Our reference: P-387800-Y4K7  
Contact: Kathryn Saunders, Principal Planner  
Telephone: (02) 4732 8567

16 November 2022

**Environmental Impact Statement - Aspect Industrial Estate (SSD-10448) -  
Stage 2 State Significant Development Application for Warehouse 9 - SSD-  
46516461**

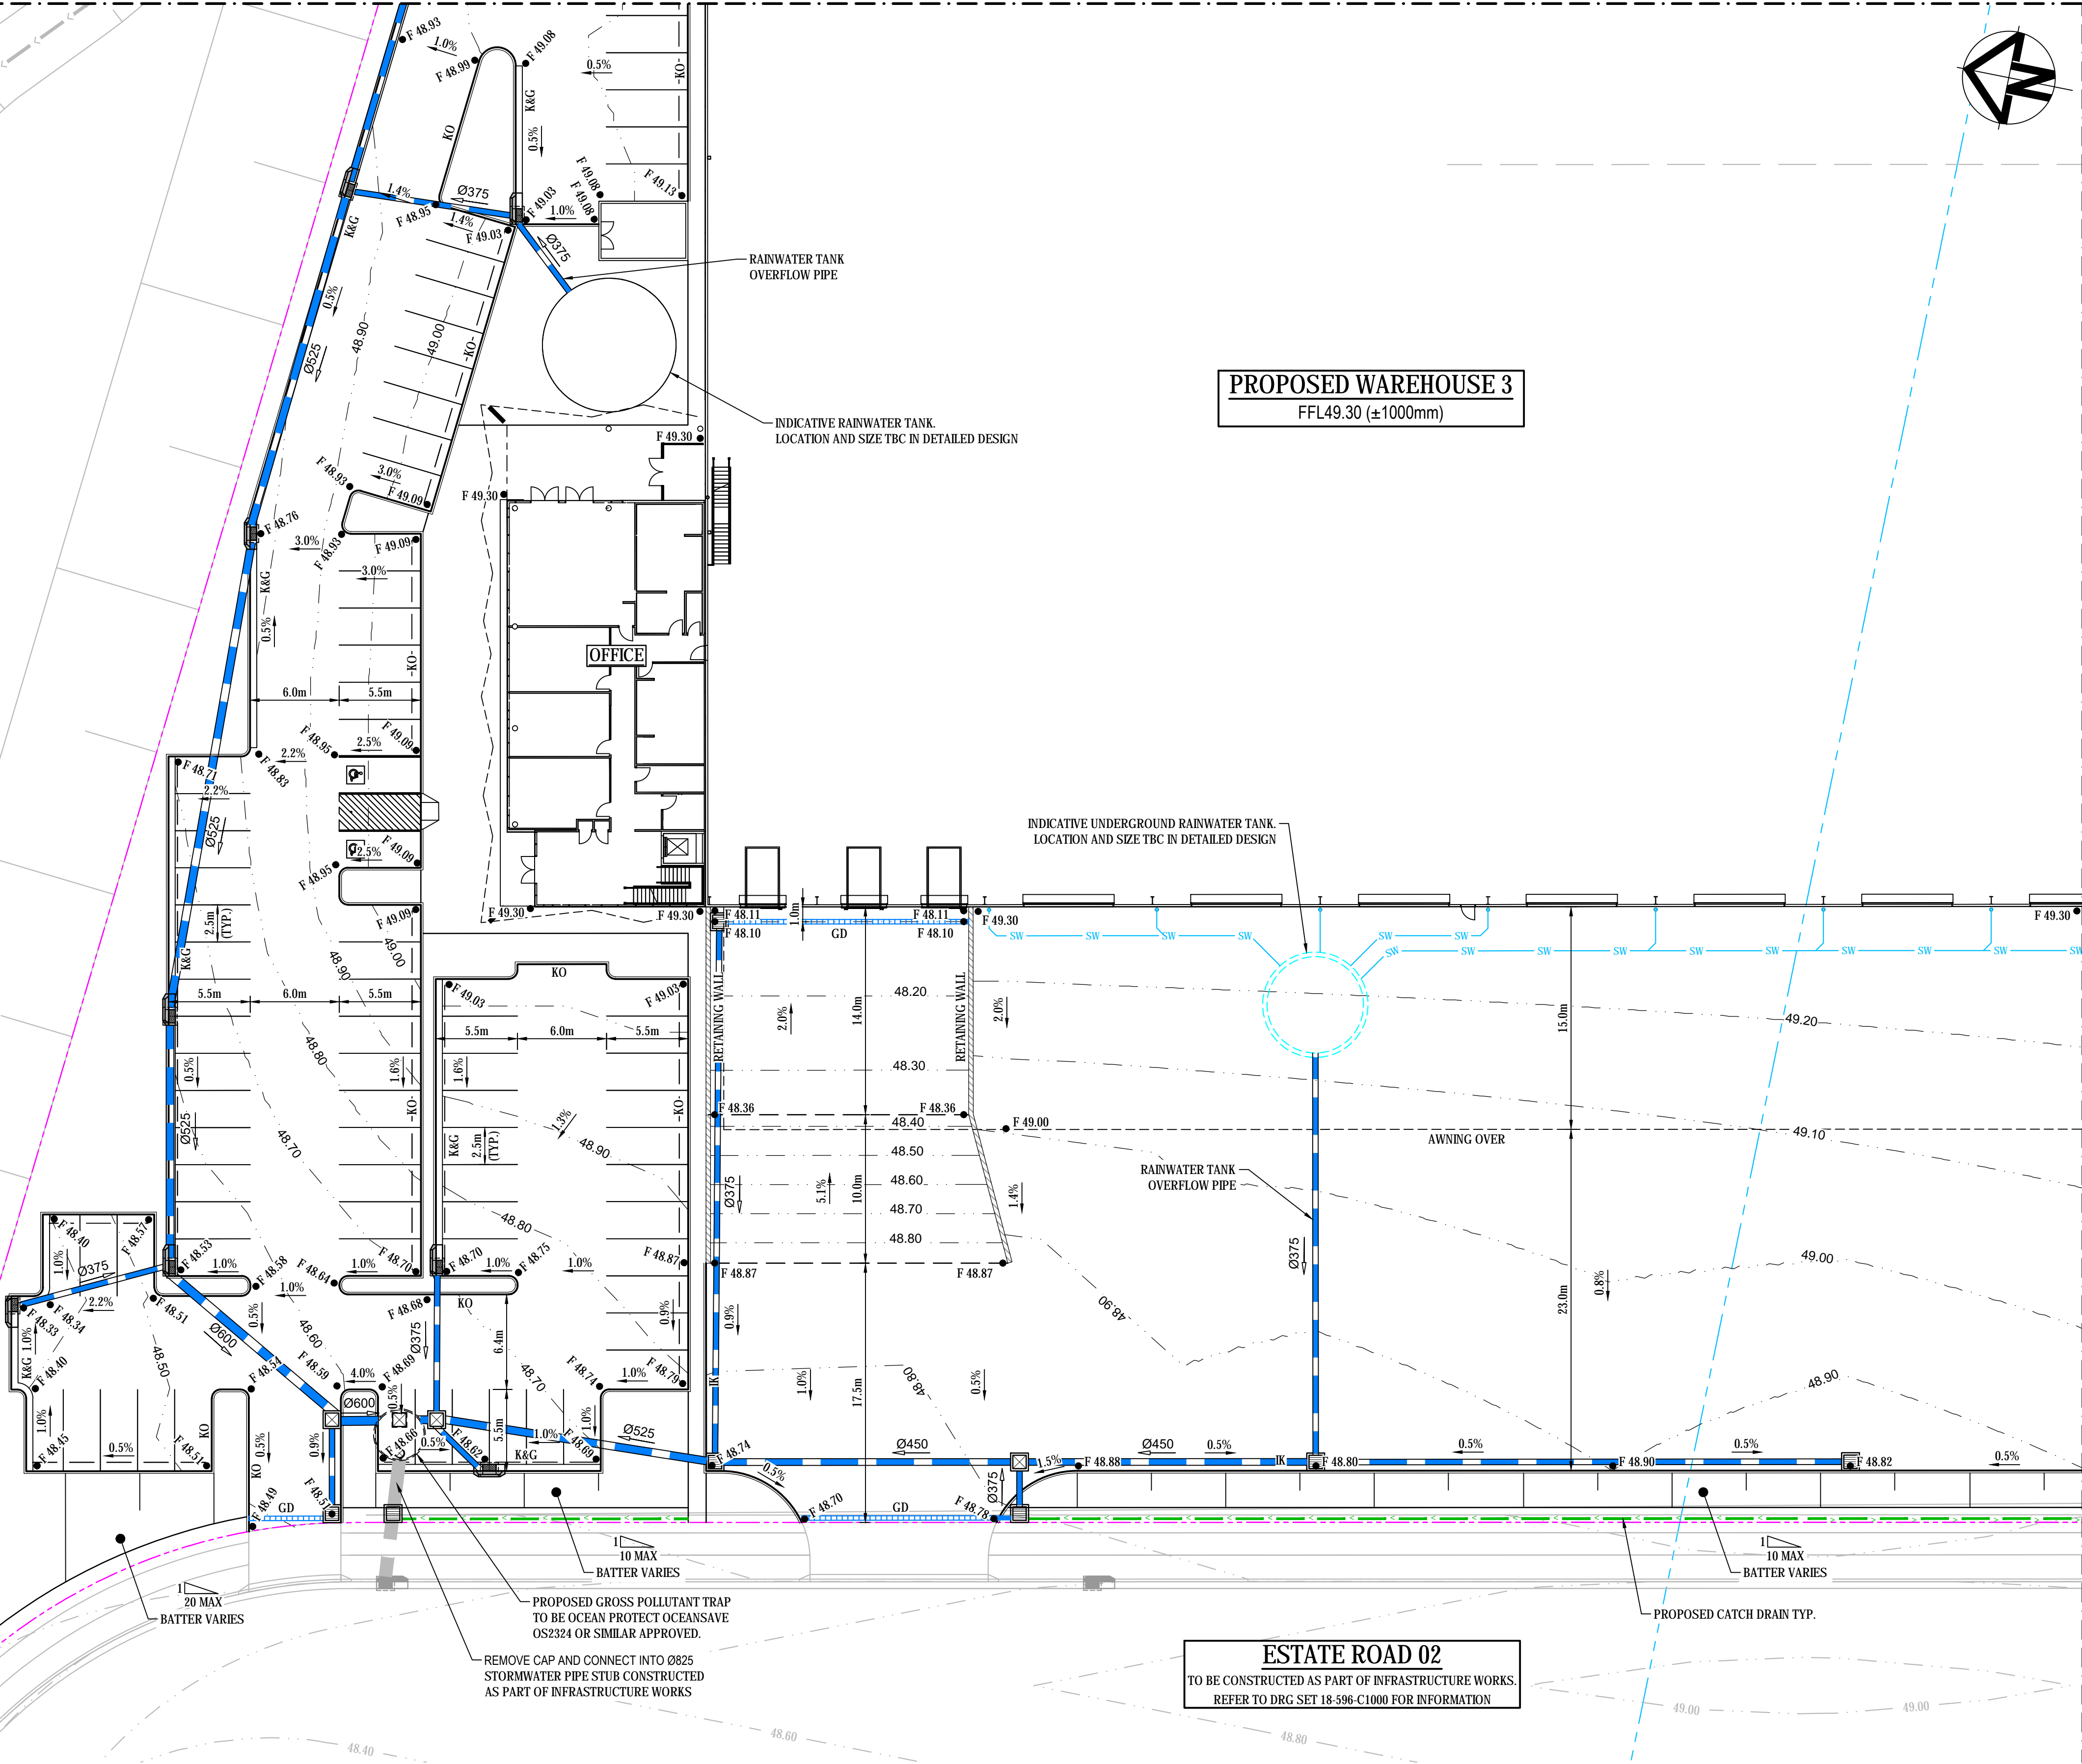
The internal car parking layout at the south-east corner of the site is not supported. All car parking areas for passenger cars shall be physically separated from heavy vehicle access and manoeuvring areas by use of a kerb or other permanent feature. The use of bollards or line marking to separate heavy vehicle areas from car parking areas is not supported.
